**WRITTEN SUBMISSIONS OF NFU AND LIG REGARDING THE NORFOLK BOREAS OFFSHORE
WINDFARM PROJECT CONSENT ORDER 201 [...]**

PLANNING INSPECTORATE REFERENCE NO EN010087

**SUBMISSIONS OF NATIONAL FARMERS UNION AND THE LAND INTEREST GROUP ON THE –
ONSHORE EFFECTS INCLUDING THE DRAFT DEVELOPMENT CONSENT ORDER ON 21
JANUARY 2020**

DATE 30TH JANUARY 2020

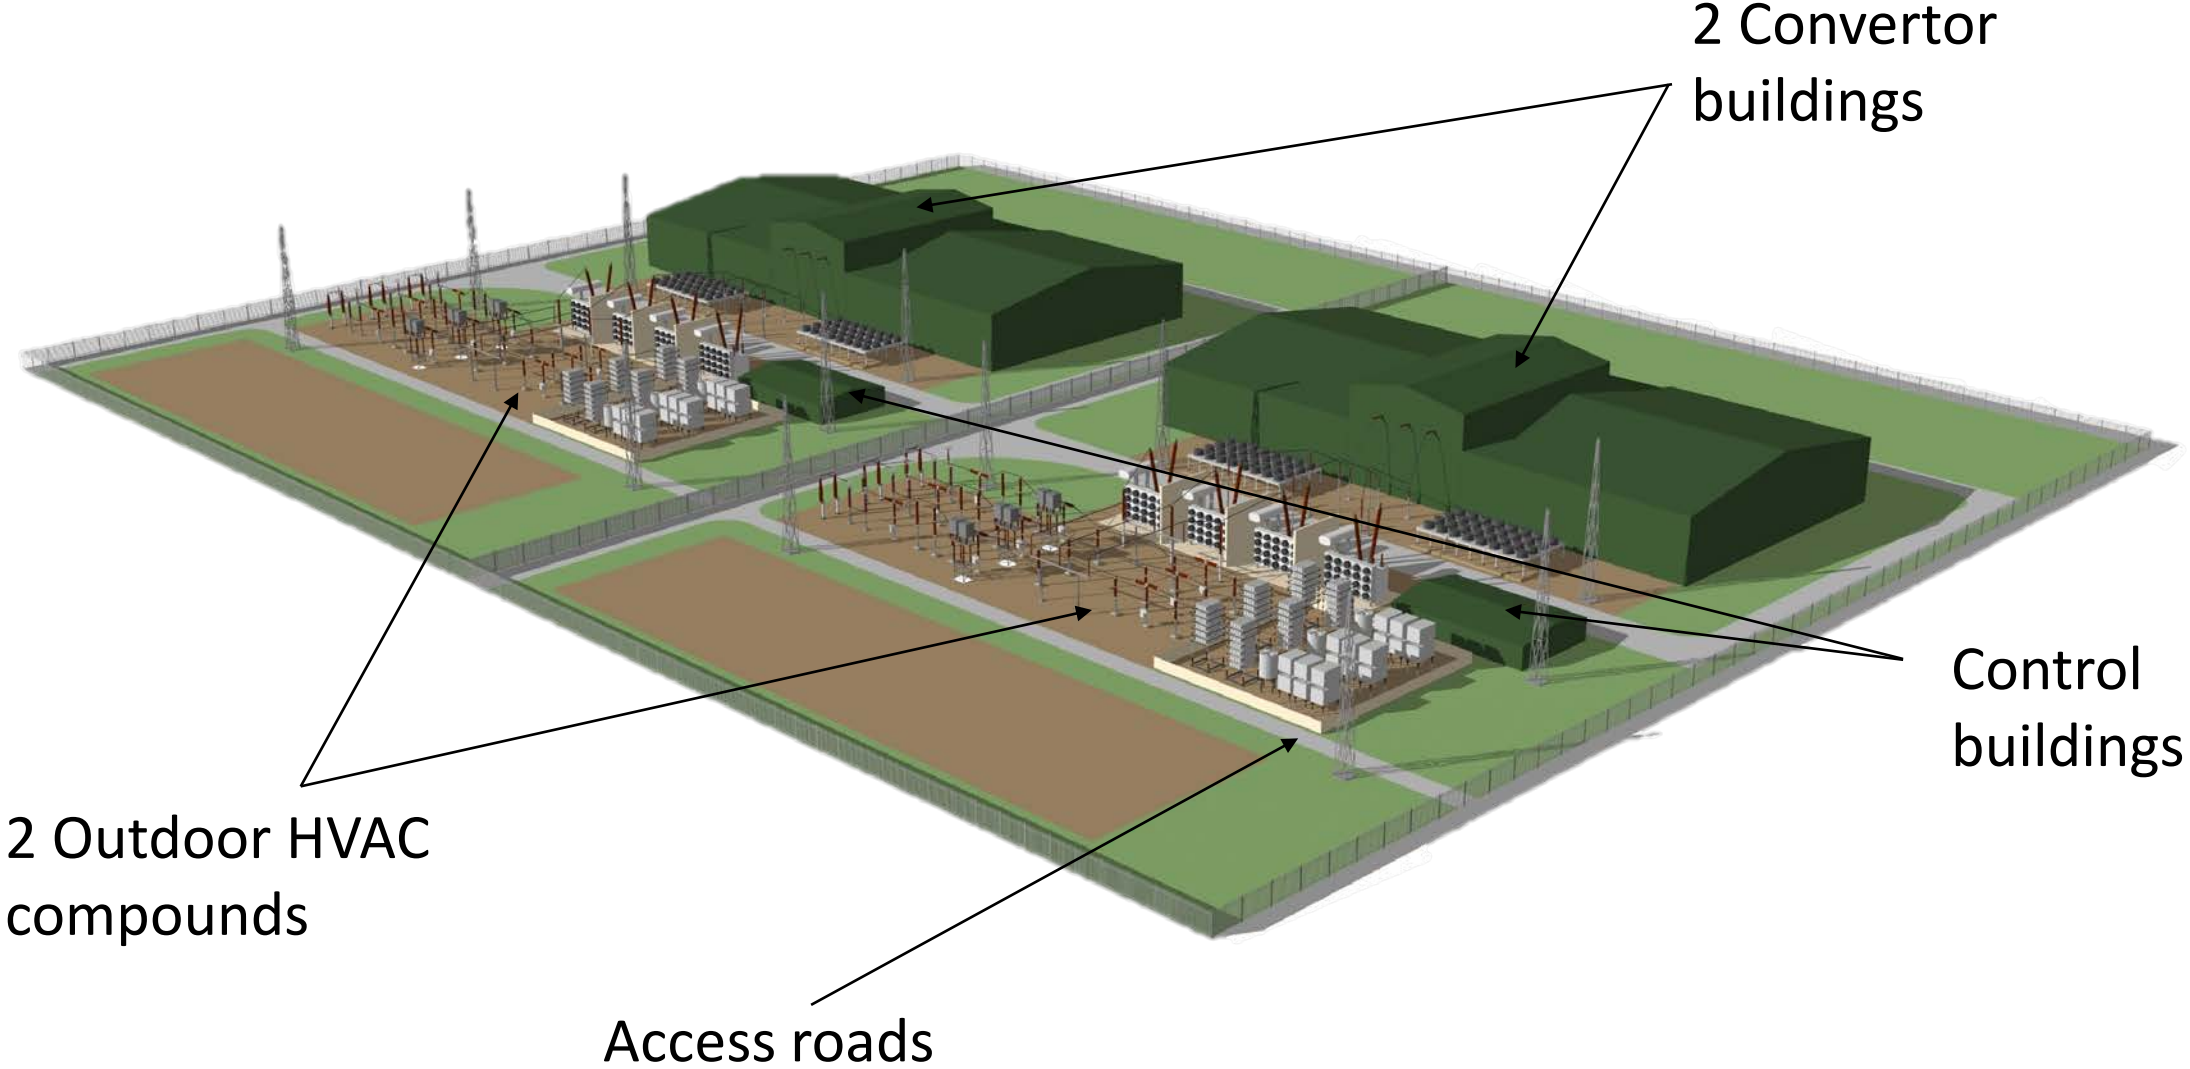
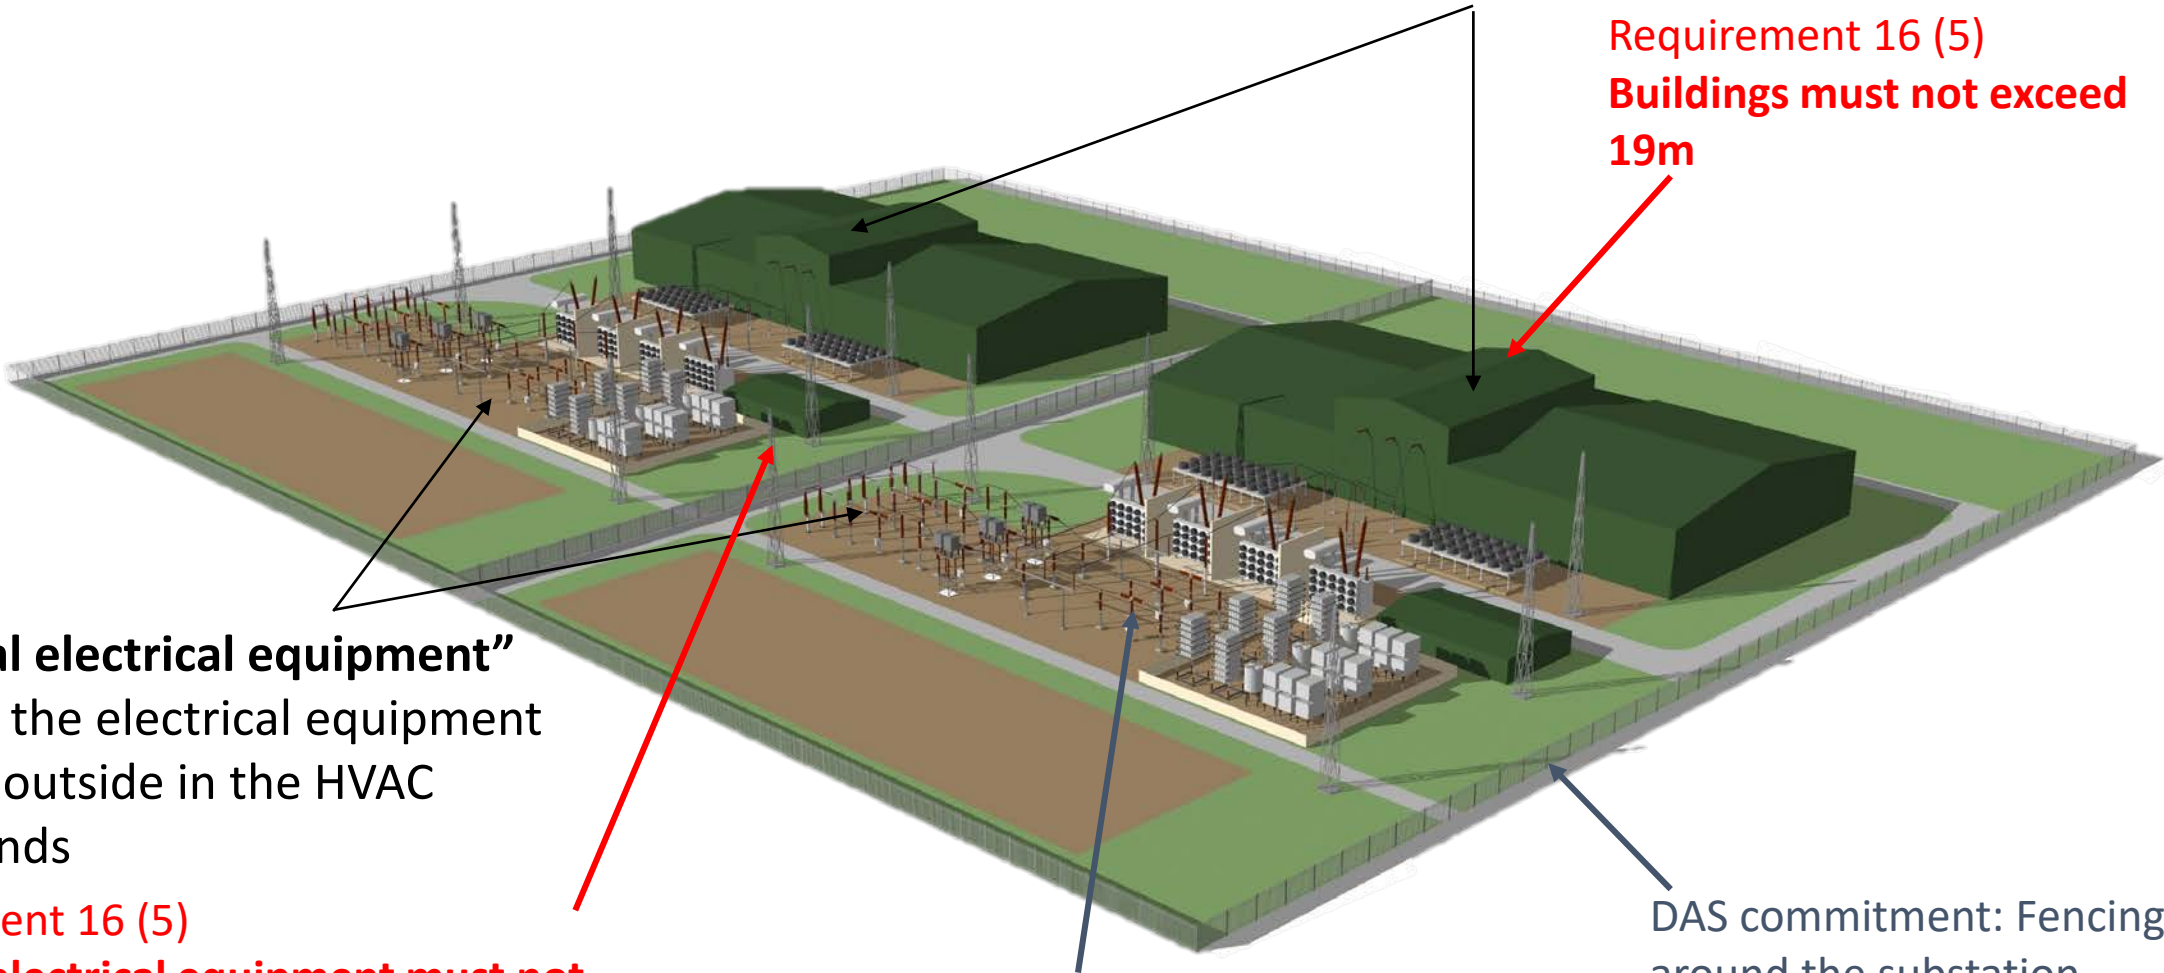
- 3.1 **Substations at Necton:** At the hearing an issue was raised over the external appearance of the building and we understand that Vattenfall will consult on this further. We believe that this is essential and we do know that other similar buildings have had a phased shade of either blue or green to blend into the landscape. It is understood that the electrical equipment will be silver.

At the hearing it was discussed whether bunding should be used around the site to help reduce visual impact. The NFU knows from experience that bunding is not always the best solution. NFU and LIG have asked Vattenfall to explain whether the building would be constructed into the slope so that the height at the lower level of the slope remains the highest point. This information was requested in the NFU SoCG on 29.11.2019 and as yet no response has been forthcoming from Vattenfall.

The NFU and LIG would be grateful for more detailed plans showing the layout of the site. Plans have now been requested on numerous occasions. Further detail is required on the position of the buildings and external electrical equipment within the site compound.
